## ENGINEERING SITE PLAN FOR EXCEL TELECOMMUNICATIONS SERVICE CENTER

**MEMORANDUM**

Date: January 2, 1996  
To: Lynn Chandler, Building official  
From: Stade Strickland, Director  
Subject: Excel Telecommunications, Inc.

Drawing file: 16675 Excel Telecommunications Service Center 1195 / 4of12 SP.pdf

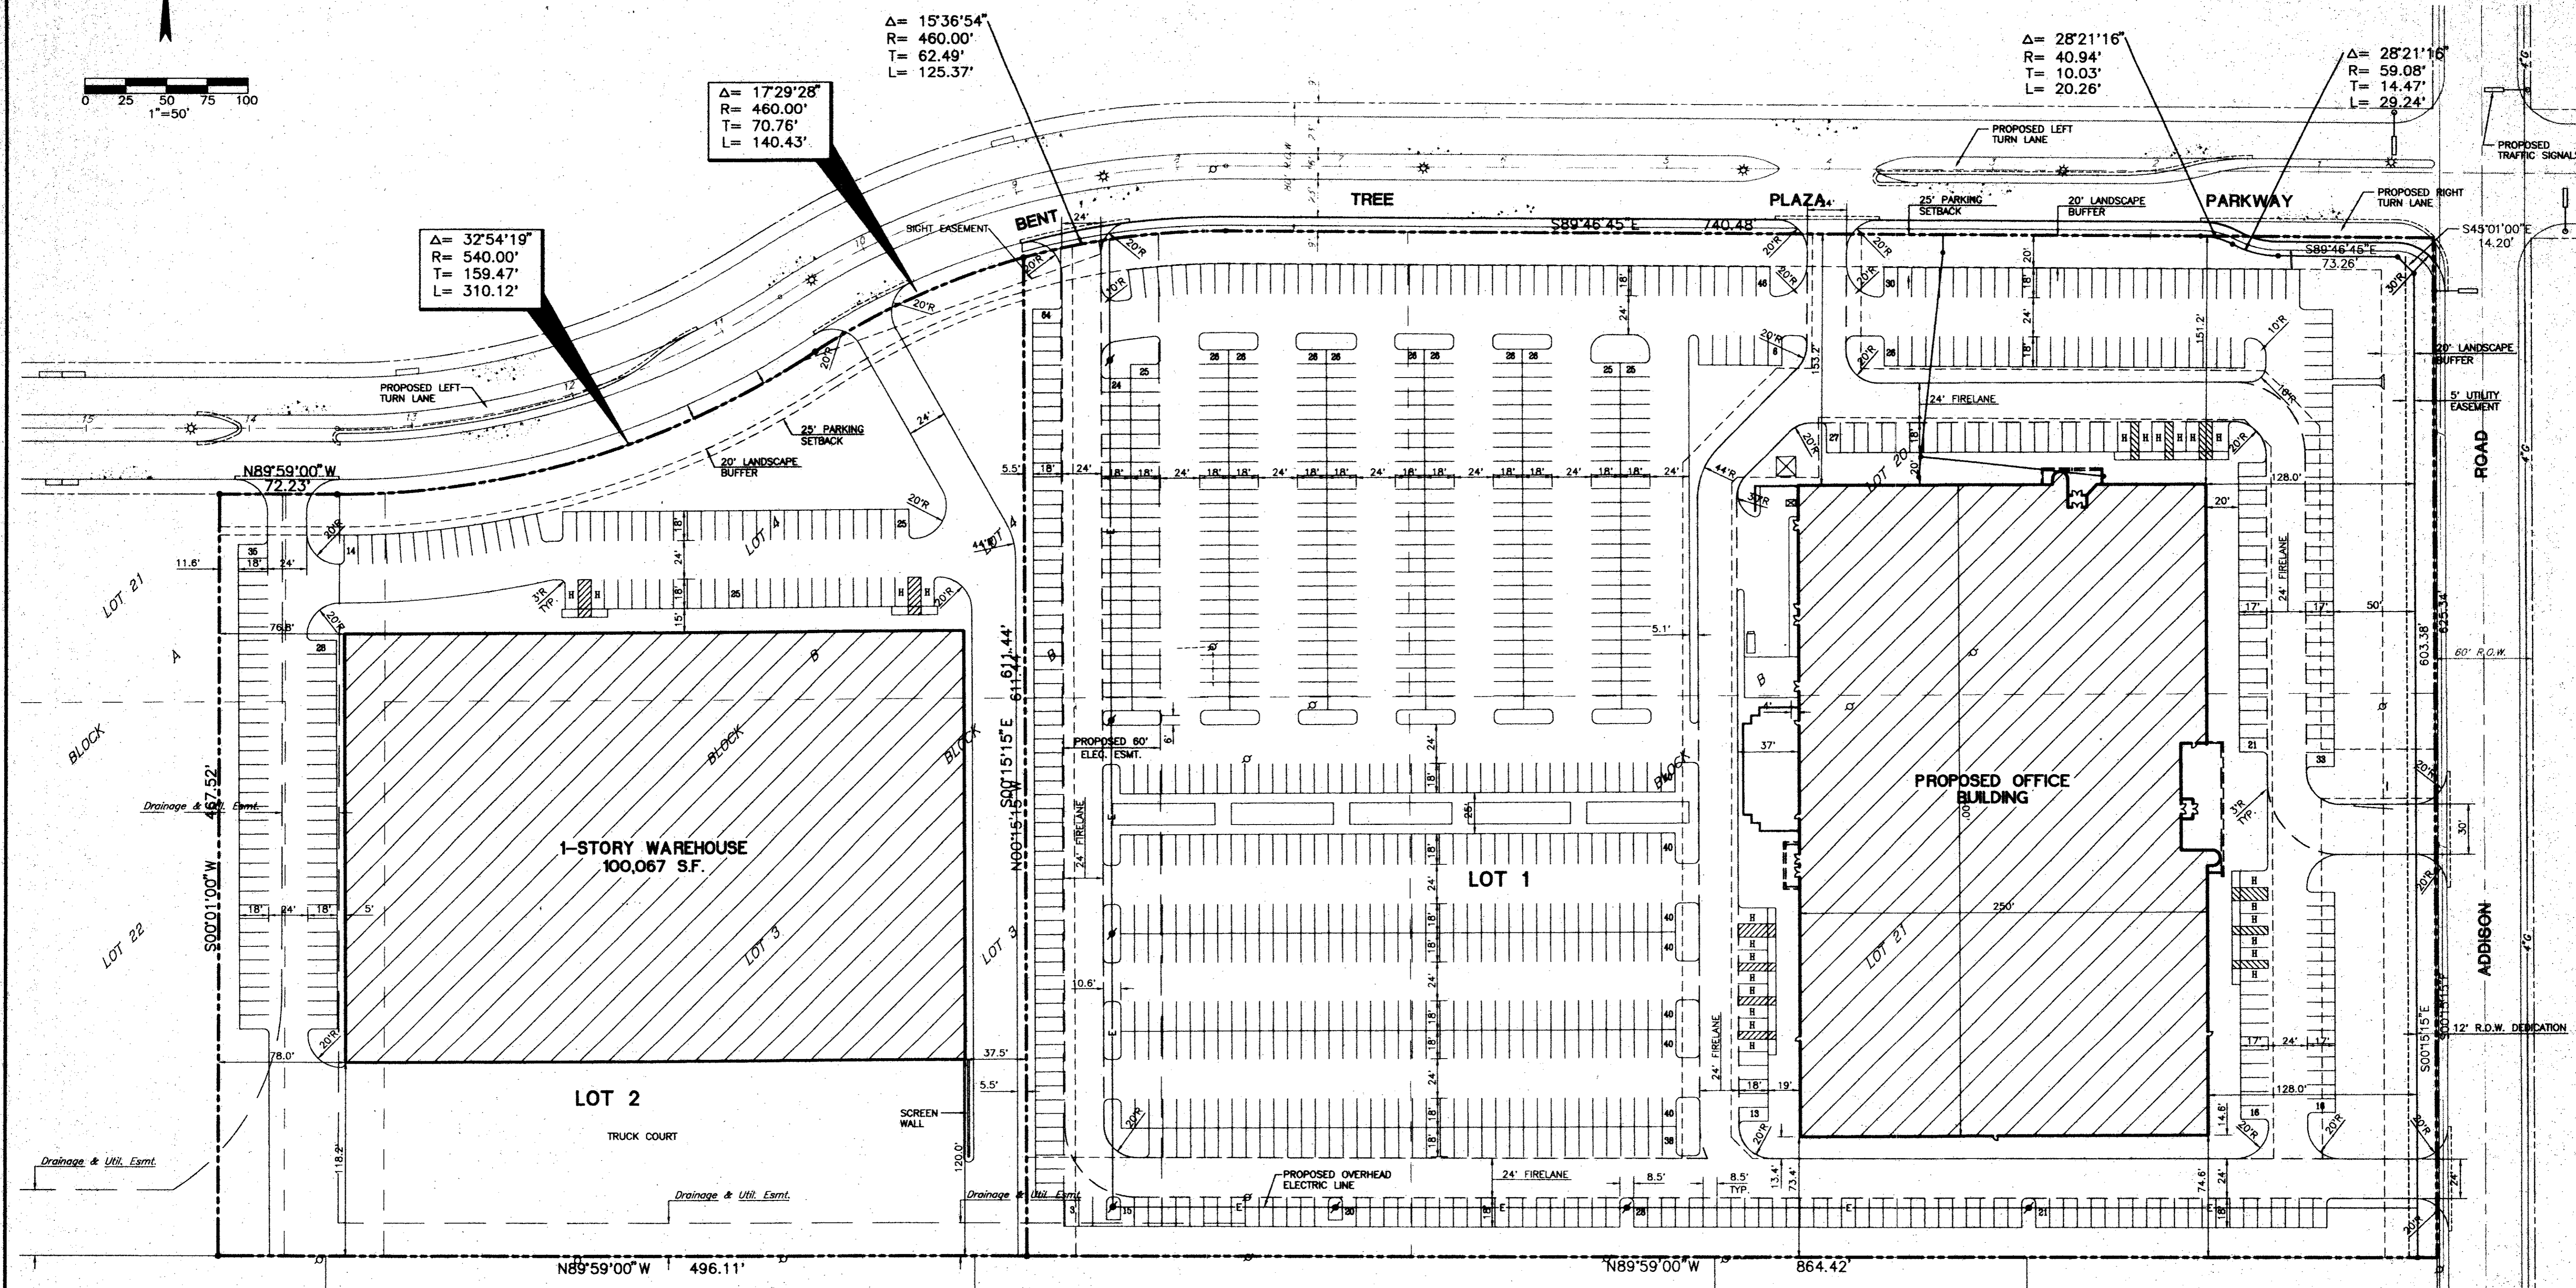
- Specify which type of grass is proposed and whether it will be sodded or seeded. Sodding is preferable;
- Add 21 shade trees to comply with the number of trees required by the landscape ordinance;
- Move all shade trees outside of the dedicated roadway area along Addison Road;
- Show a 5 feet wide sidewalk along Addison Road.
- Show benning along Addison Road and Bent Tree Plaza Parkway

The detention area shown along Addison Road is inconsistent with the intent of the landscape ordinance because it provides no visual buffering of the building and the parking lot. It needs to be located to the south or west side of the site behind the building so it can't be seen from the street.

Question Regarding Detention Area Along Addison Road - Much Larger than Preliminary Proposal - Move Detention to Rear of Property - Inappropriate Use as Landscape Buffer Along Addison Road.
